May 2, 2022

Re: Carrillo Shop
1001 Coors SW
Traffic Circulation Layout
Engineer's Stamp NONE (L11-D010)

Based upon the information provided in your submittal received 04-26-2022, the above referenced plan cannot be approved for Building Permit until the following comments are addressed:

PROPOSED
TRANSPORTATION
PLAN

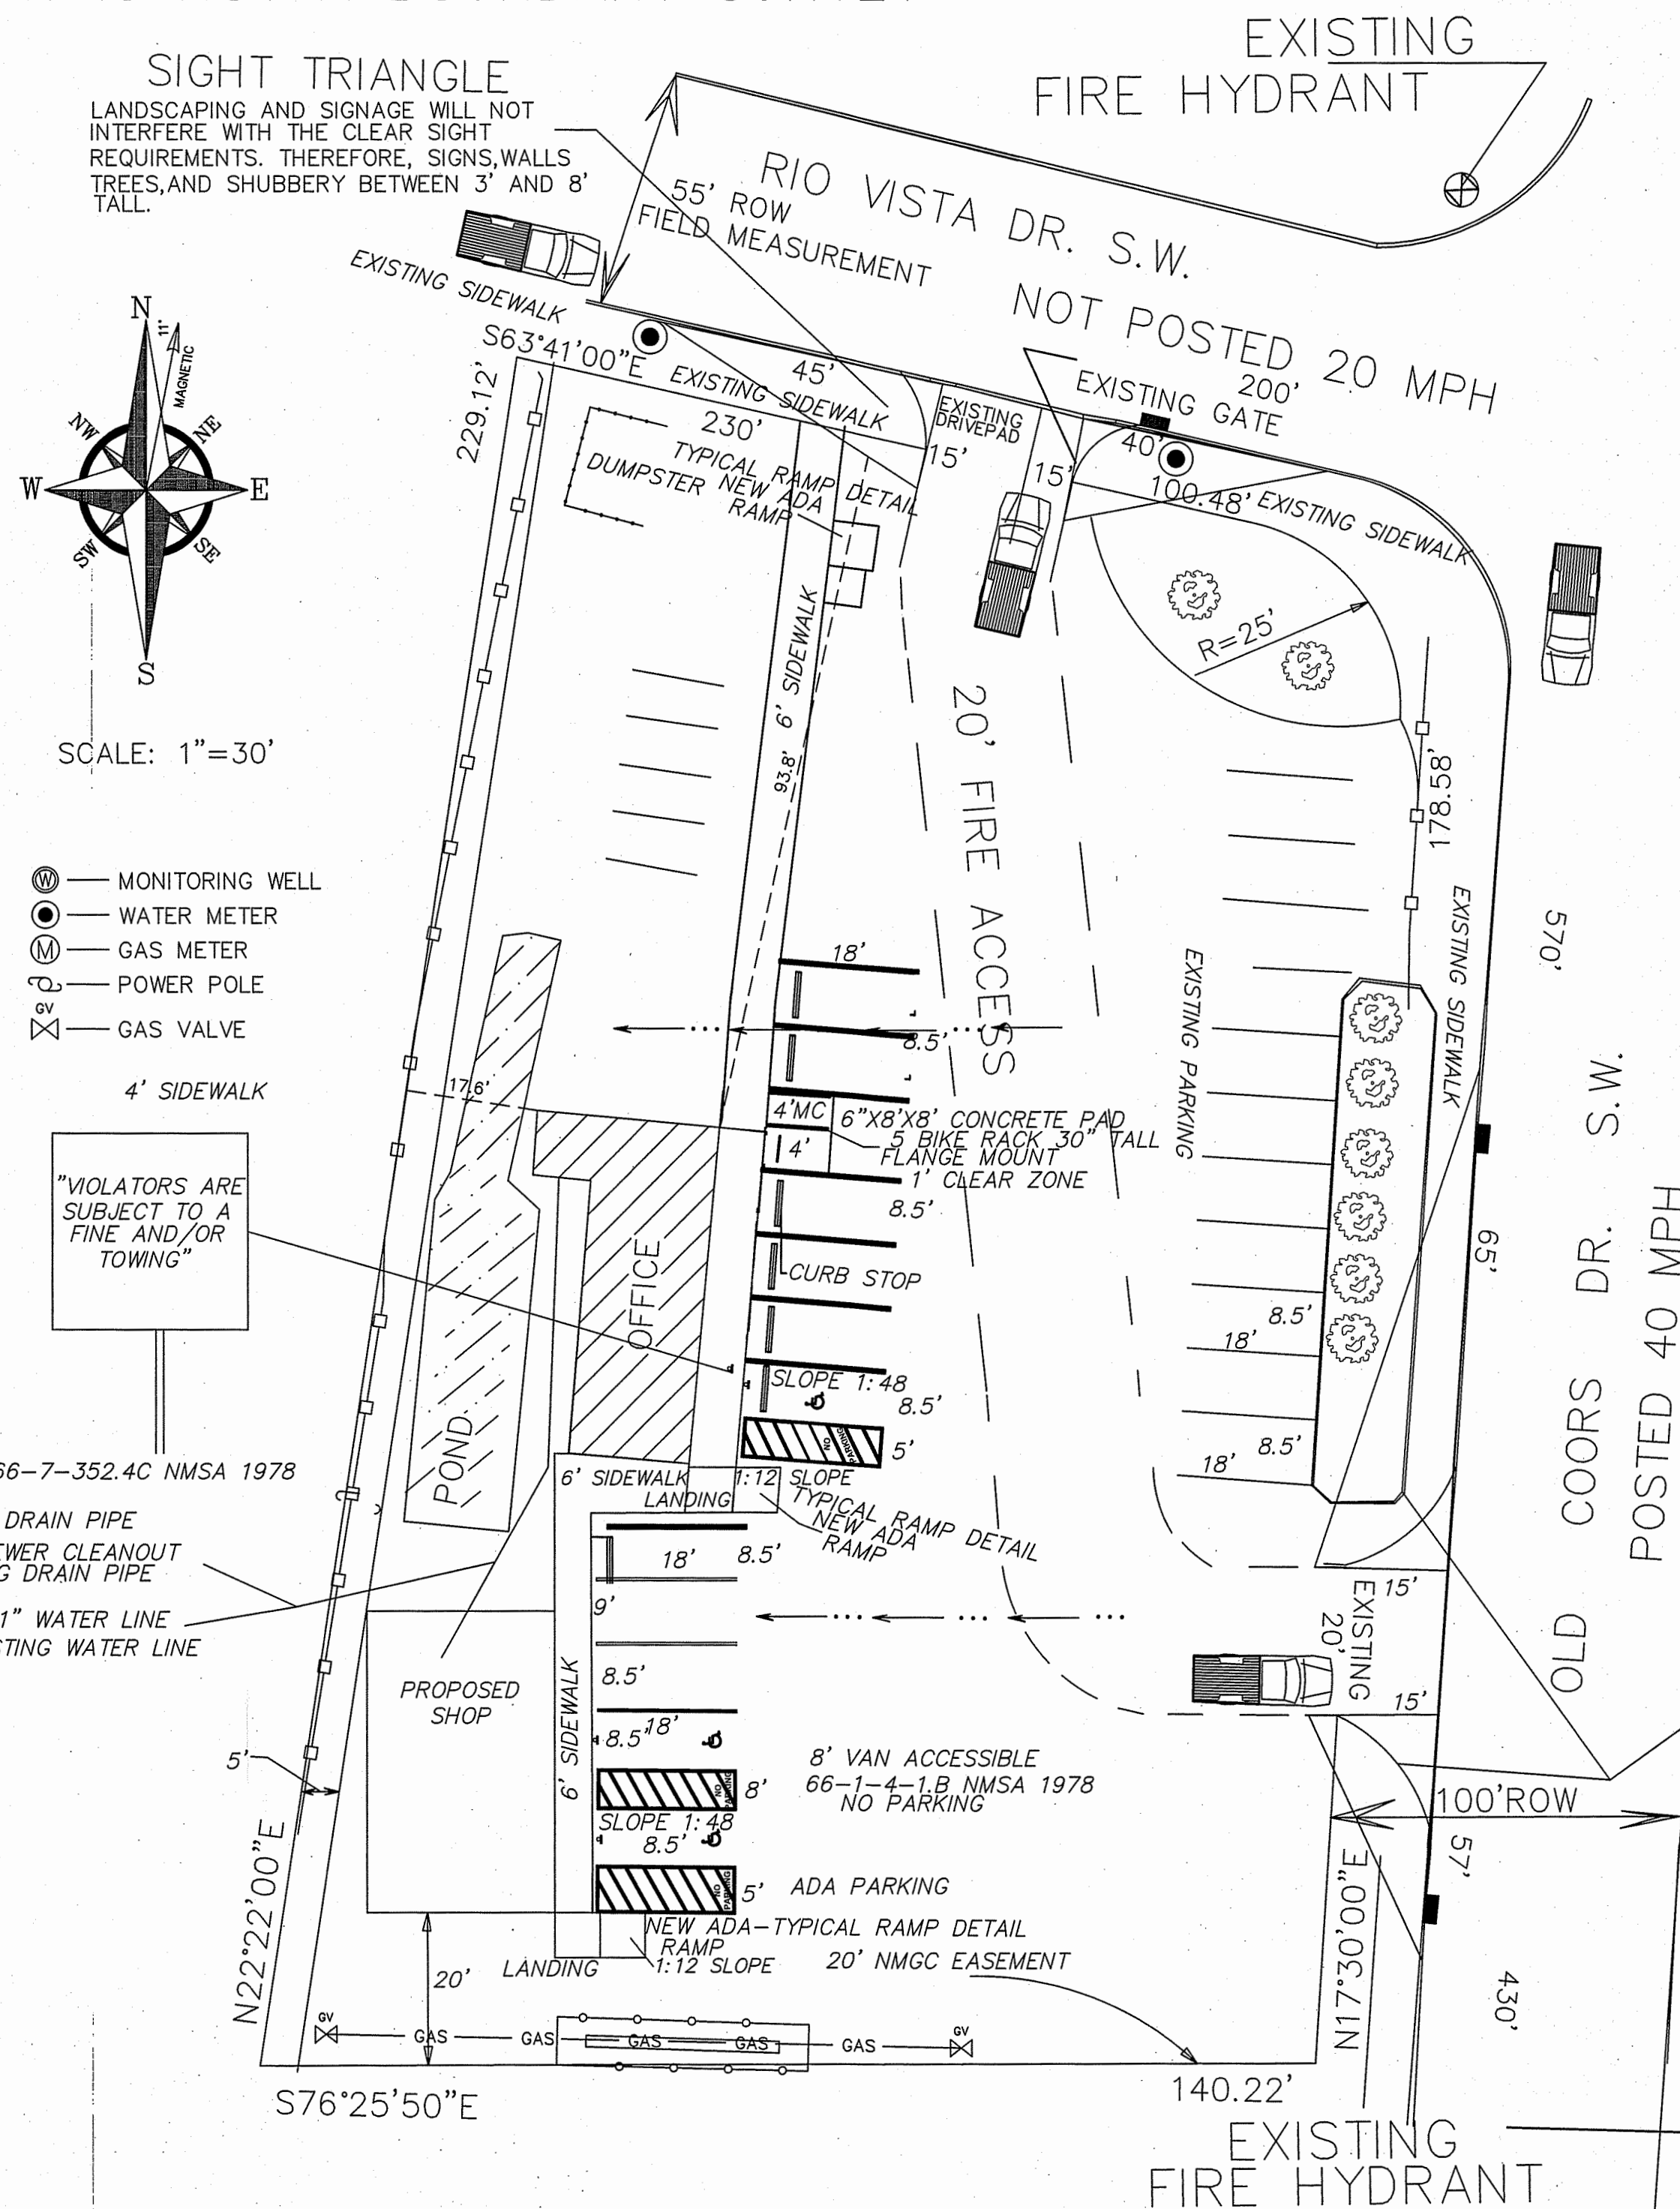
4. Corner of Rio Vista/Old Coors: Existing ramp will need to be verified that it is current/update ADA accessible. ADA curb ramps must be updated to current standards and have truncated domes installed.

29. Add a note stating "All broken or cracked sidewalk must be replaced with sidewalk and curb & gutter." A build note must be provided referring to the appropriate City Standard drawing (2430 & 2415A).

PROPOSED SITE PLAN / ADA PARKING

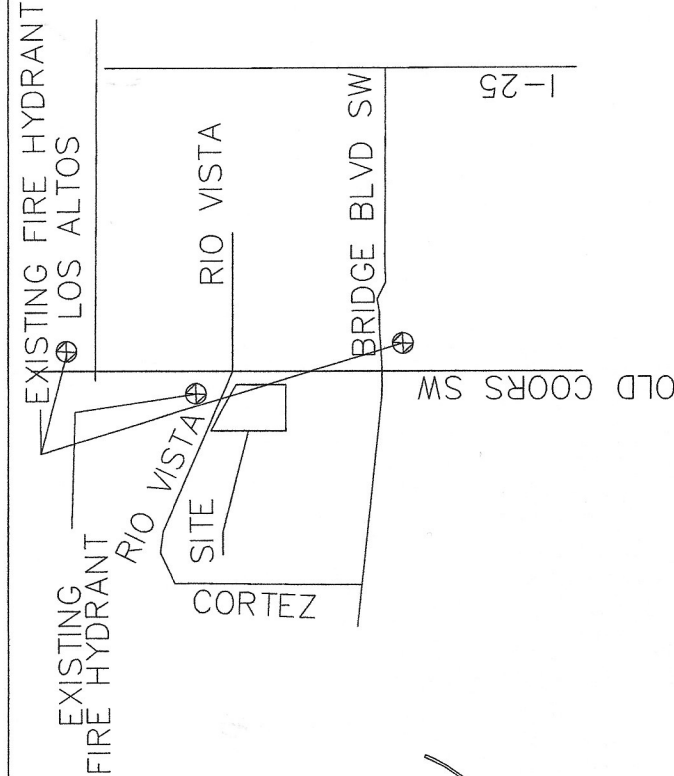
1. You will need to list are the number of parking spaces **required by the IDO** as well as the proposed number of parking spaces **including bicycle and motorcycle parking.** **Coordinate/discuss with Zoning.**

2. The traffic circulation layout must be stamped, signed, and dated by an engineer or architect licensed in the state of New Mexico.
3. Please verify that the driveways of Rio Vista Dr and Old Coors are current/update ADA accessible.

6. Identify the right of way width, medians, curb cuts, and street widths on Rio Vista and Old Coors.
7. Please list the width and length for all existing and proposed parking spaces. Some dimensions are not shown.

9. The ADA accessible spaces must include an access aisle. Van accessible aisles should be **8ft wide**; all others should be **5ft wide**.
10. The ADA accessible parking sign must have the required language per 66-7-352.4C NMSA 1978 **"Violators Are Subject to a Fine and/or Towing."** Please call out detail and location of signs.

11. The ADA access aisles shall have the words **"NO PARKING"** in capital letters, each of which shall be at least one foot high and at least two inches wide, placed at the rear of the parking space so as to be close to where an adjacent vehicle's rear tire would be placed. (66-1-4.1.B NMSA 1978)

12. Motorcycle parking spaces shall be designated by its own conspicuously posted upright sign, either free-standing or wall mounted per the zoning code. Label pavement MC.

17. Show all drive aisle widths and entrance drive. Some dimensions are not shown.
18. The minimum drive aisle dimensions are shown below

20. Per the DPM, a 6 ft. wide ADA accessible pedestrian pathway is required from the public sidewalk to the building entrances. Please clearly show this pathway and provide details.

21. Per DPM, a 6 ft. wide ADA accessible pedestrian pathway is required from the ADA parking stall access aisles to the building entrances. Please clearly show this pathway and provide details.

22. Curbing should be installed to delineate landscape, parking, and pedestrian ways and identify points of access. Please call out detail and location of barrier curb.

26. It is not apparent what type of pavement surface is being proposed. A hard driving surface will be required as part of this proposed project for parking area and drive aisles.

27. Please provide a sight distance exhibit
28. Show the clear sight triangle and add the following note to the plan: "Landscaping and signage will not interfere with clear sight requirements. Therefore, signs, walls, trees, and shrubbery between 3 and 8 feet tall (as measured from the gutter pan) will not be acceptable in the clear sight triangle.
